I would like to make my objection to PATHWAYS CREMORNE SENIORS HOUSING (SSD-49472213) known for the following reasons:

Owner/Resident of 92 Parraween St, Cremorne

2 SITE SECTION / BUILDING 3 NORTHEAST ELEVATION

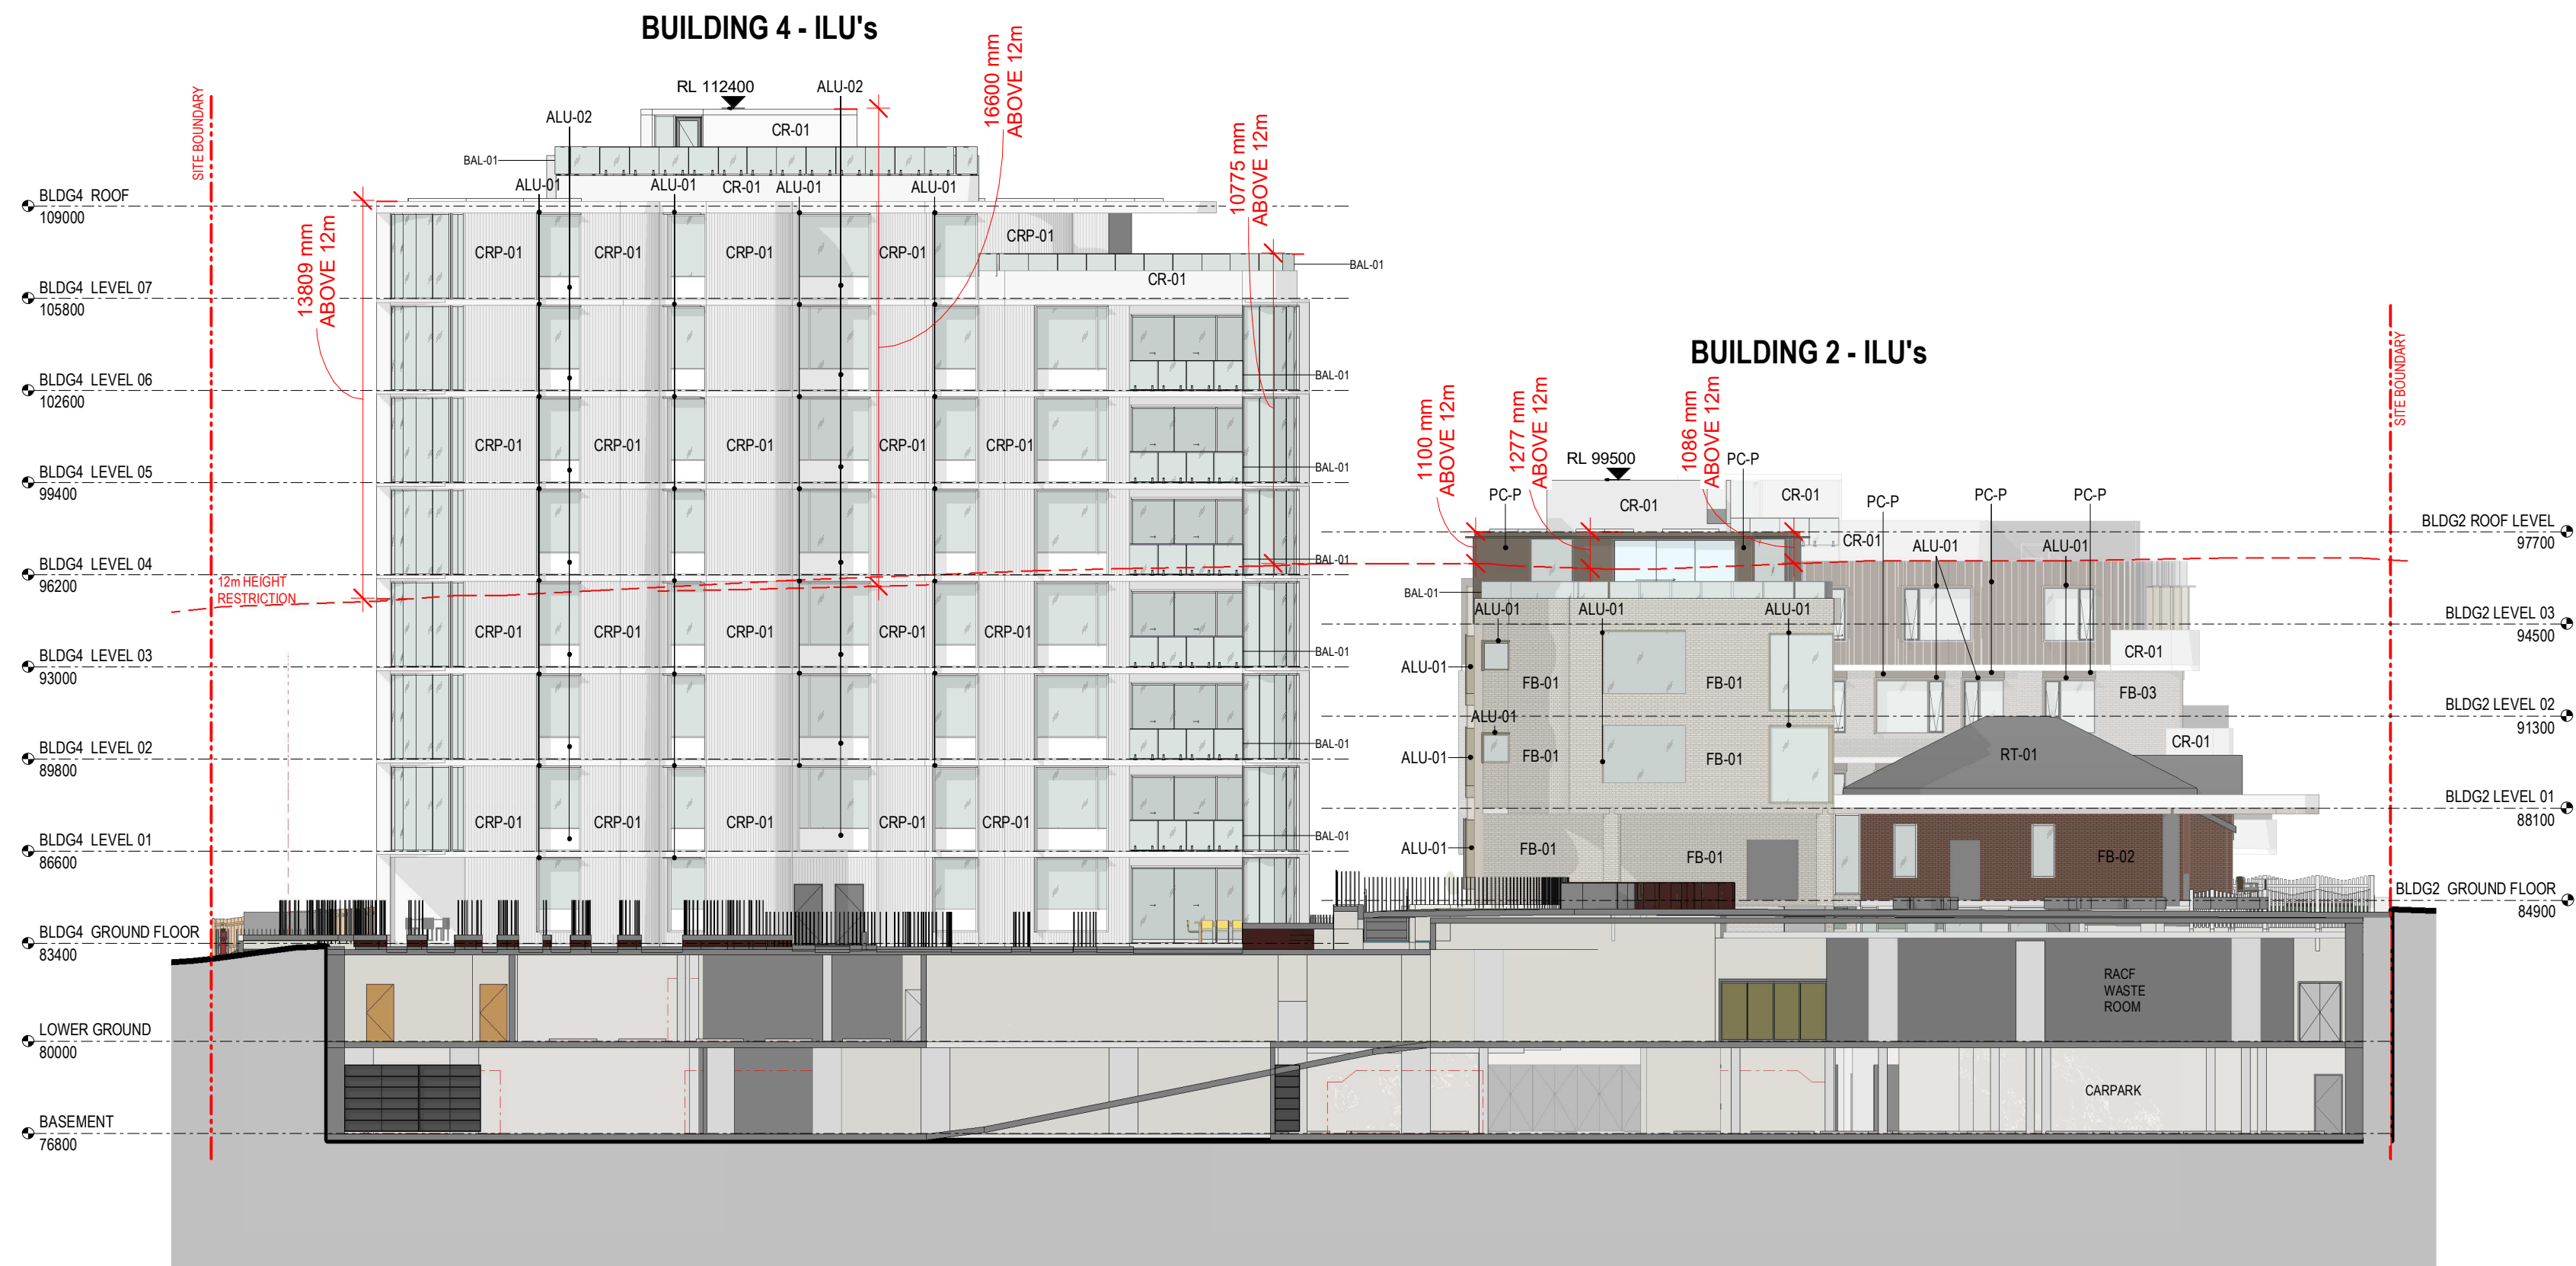
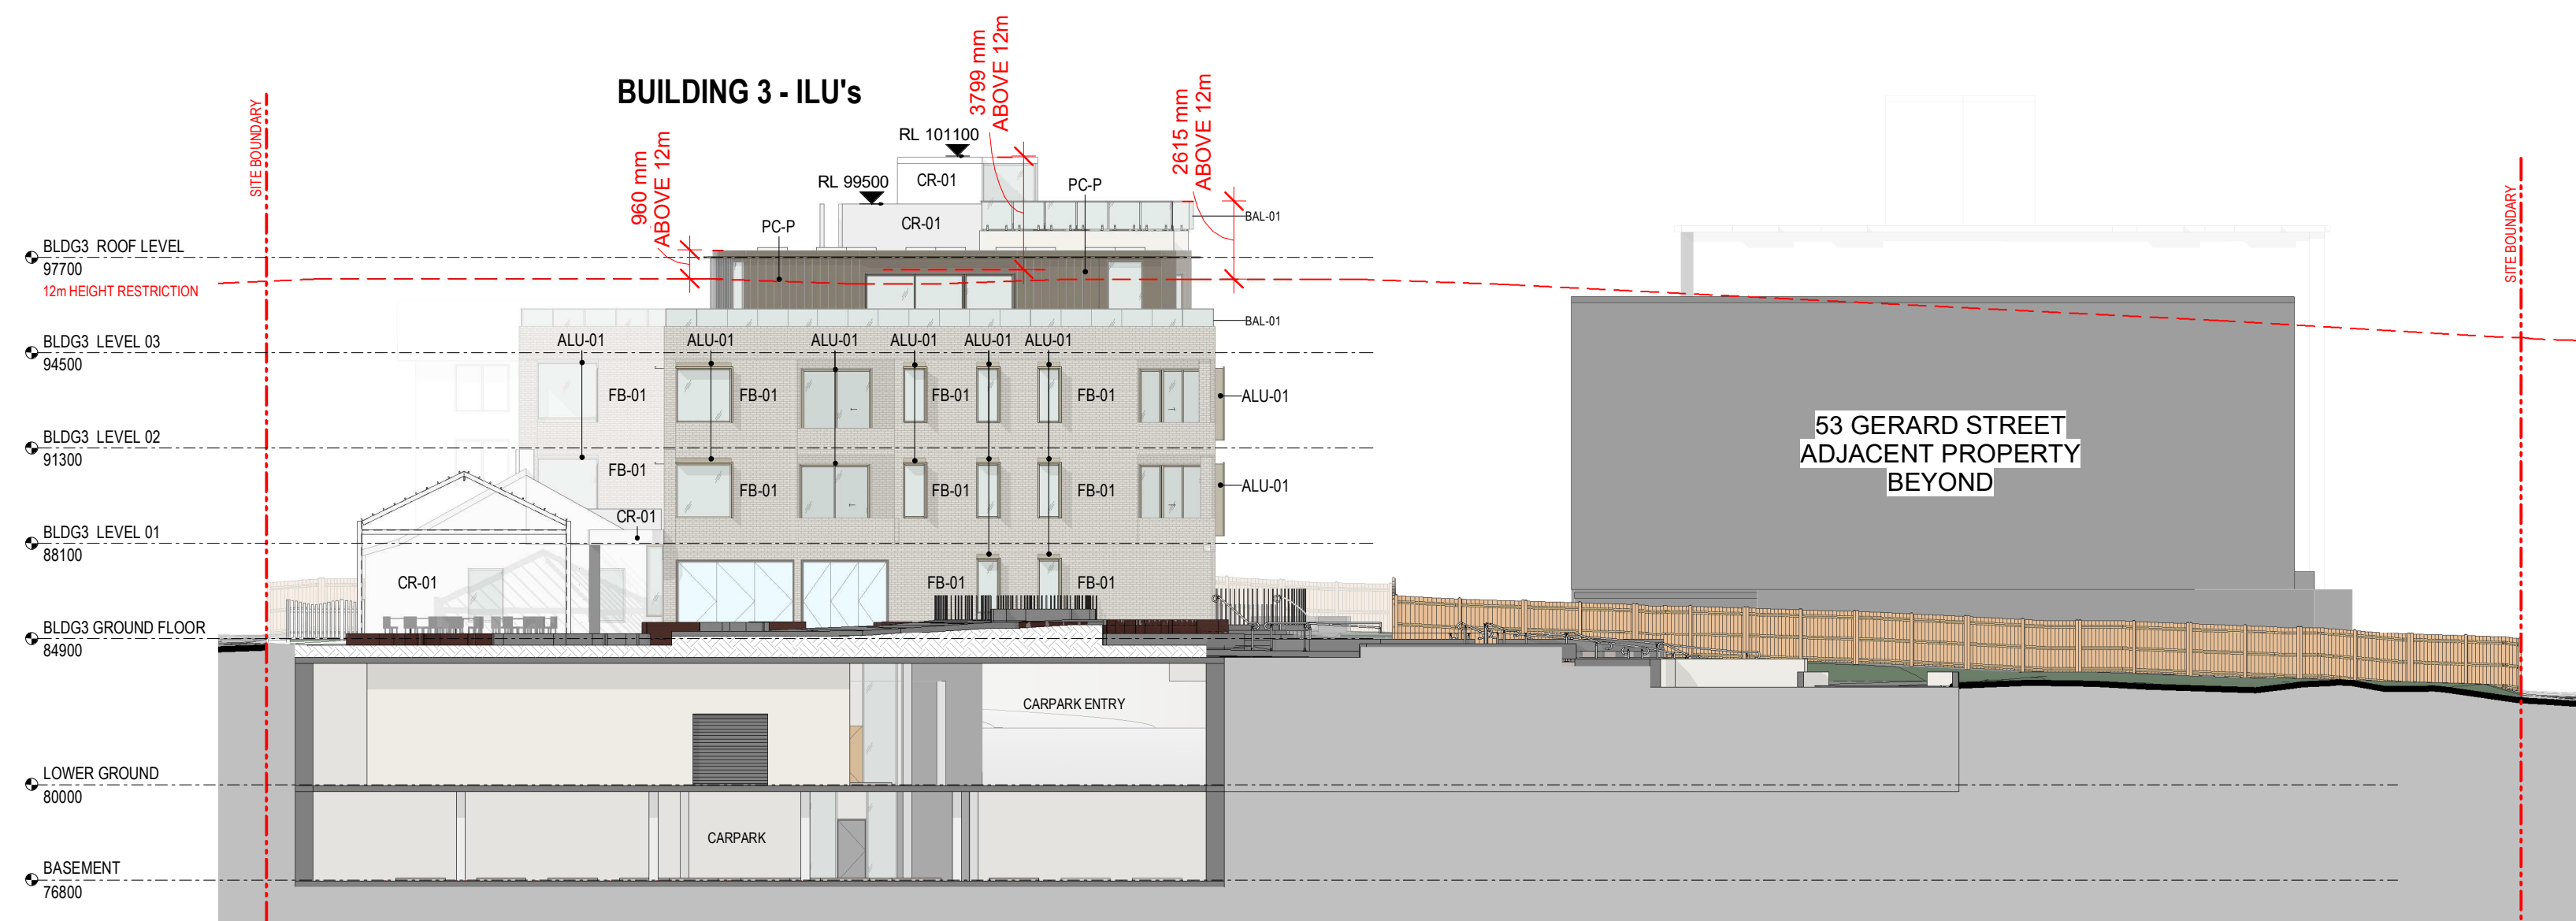
There is also a lack of detail about the elevation of building 1 in the amended application. On the architectural drawings 6 they show balconies on the eastern side of building 1 that wrap the whole way around the eastern side-where they could seemingly look right into 92 Parraween street apartments. This is contrary to OBJECTIVE 3F-1 “Adequate building separation distances are shared equitably between neighbouring sites, to achieve reasonable levels of external and internal visual privacy -taken from page B104 Amendment report. This is the only architectural drawing I could find from the view from 92 Parraween street (taken from architectural drawing 5).

2 NORTHEAST ELEVATION
SCALE 1 : 200
(TO 90 PARRAWEE STREET & 81B GERARD STREET)

I also think this drawing shows 92 Parrawee Street being overshadowed by building 1 source [The Design — Pathways Cremorne](#).

The tree that they claim they want to keep on the north eastern boundary would not fit on architectural drawing 5 due to it's roots being cut/ water table being lowered due to the foundation being dug out or it would have to have all of it's southern facing branches cut. This would be a loss to local biodiversity and green space. This would undoubtedly kill the tree.
